From: Clare Bartlett [REDACTED]
Sent: 24 April 2018 17:52
To: Anita Gardner
Subject: RE: A/17/18/PL - Buildings at Decoy Barn, Decoy Lane, Poling

PROPOSED SOUTH ELEVATION

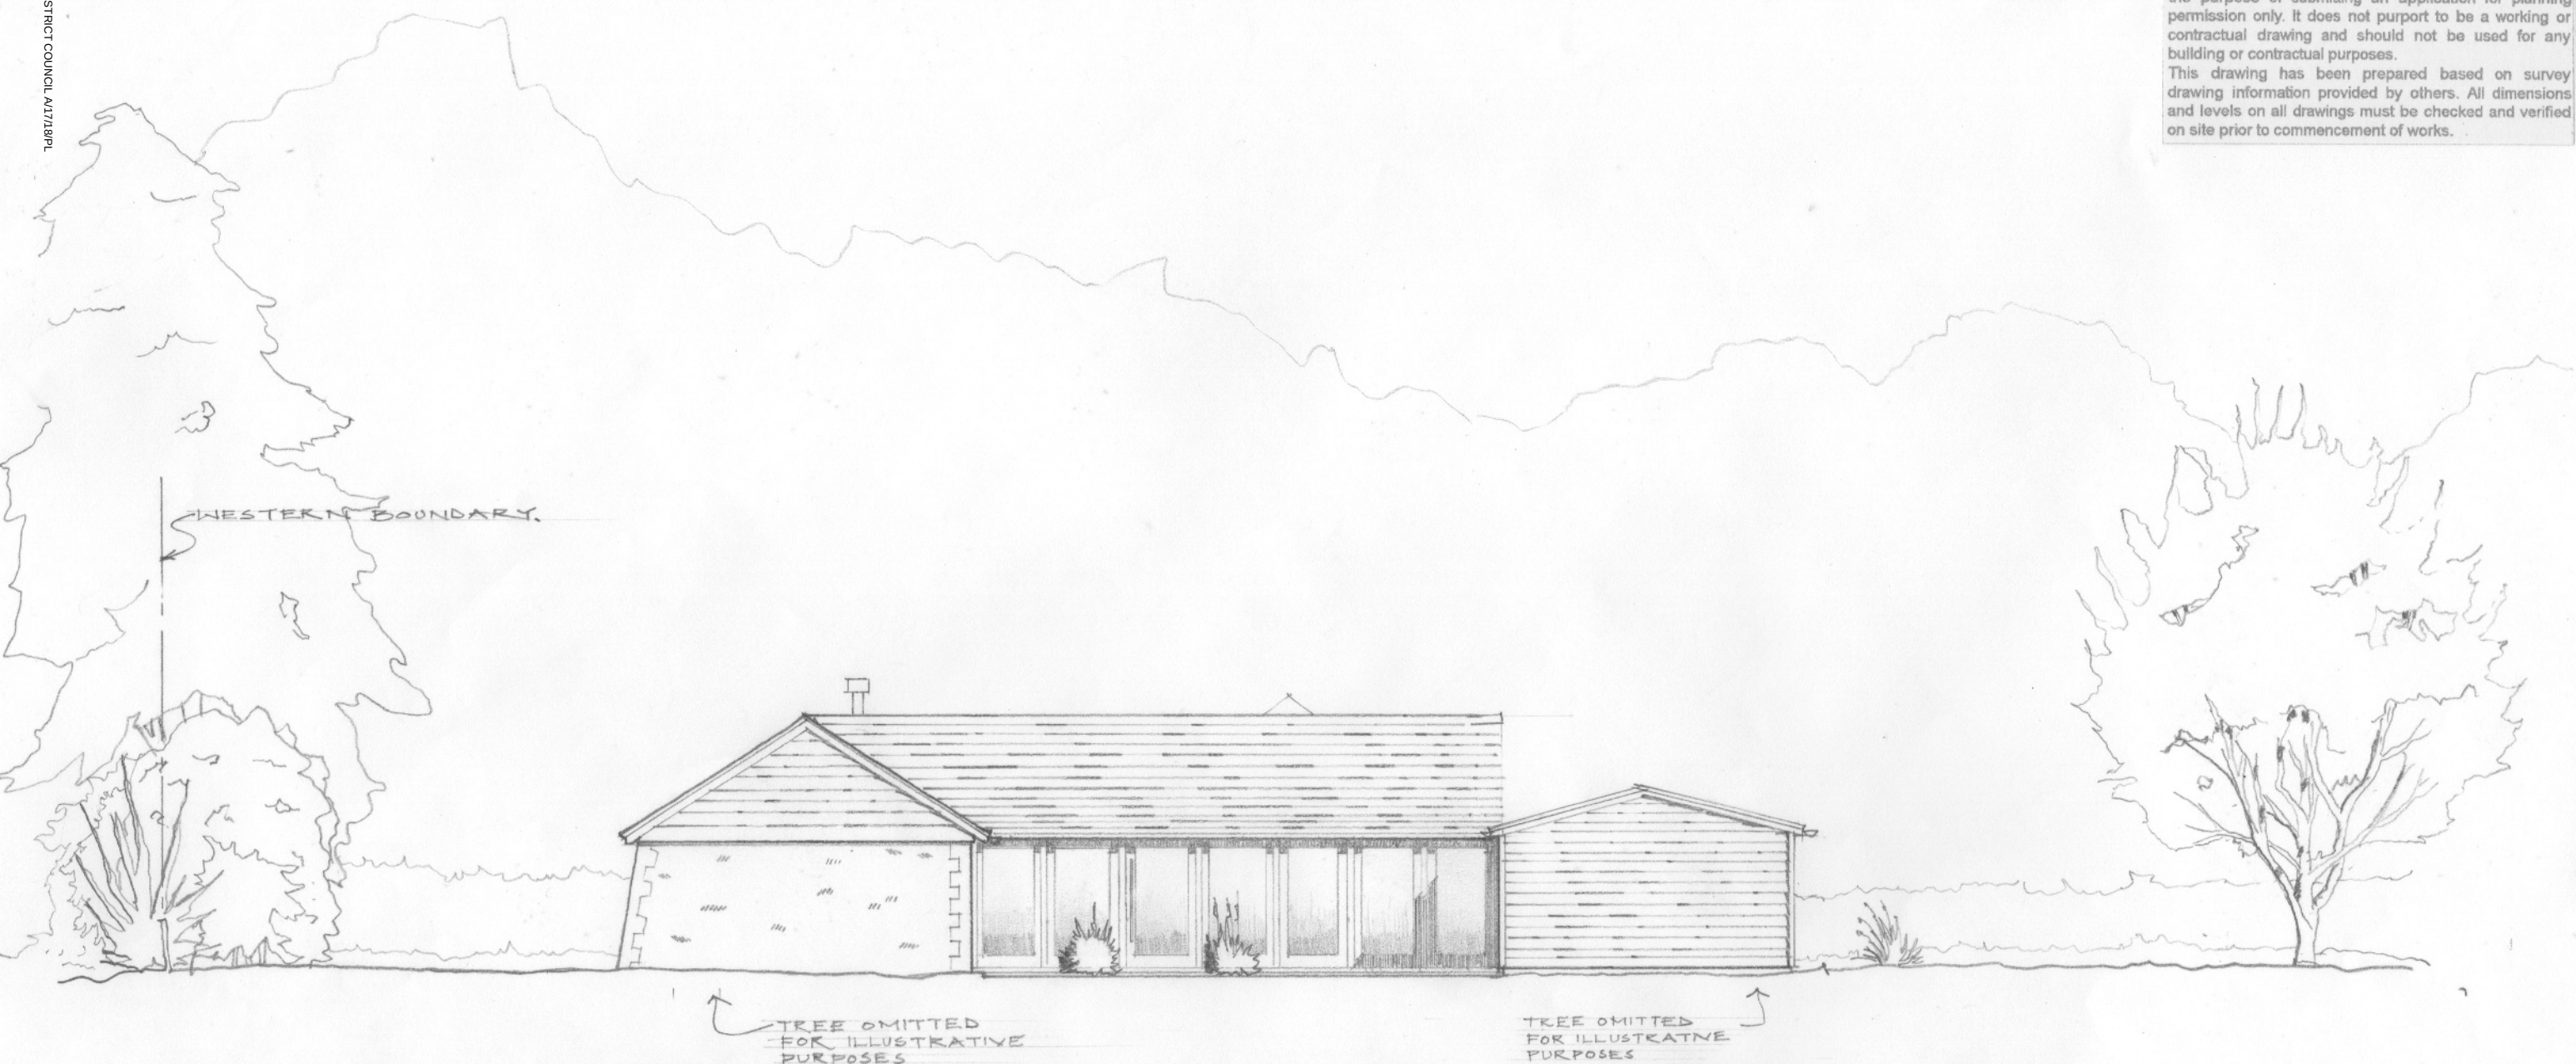
I have discussed the application with my team leader. Whilst we feel there is sufficient justification to make an exception in terms of policy DEV2 and support conversion directly to residential, instead of commercial/business use first, we do have concerns regarding the amount of glazing in the elevations facing the internal courtyard area, particularly the south, east and west and consider this would conflict with the policy which does not allow significant alteration or extension.

It is therefore my intention to write the application up for refusal, though this is unlikely to be completed until the end of the week and I would appreciate your agreement to an extension of time until 27-04-2018 to facilitate this. Alternatively, I am prepared to allow time for the receipt of revised elevation and floor plans reducing the extent of the glazing/openings and would appreciate an extension of time until 11-05-2018 to allow for receipt and processing of revised plans.

Thanks Anita, I confirm the applicant will be submitting revised plans and is agreeable to an extension of time until 11th May.
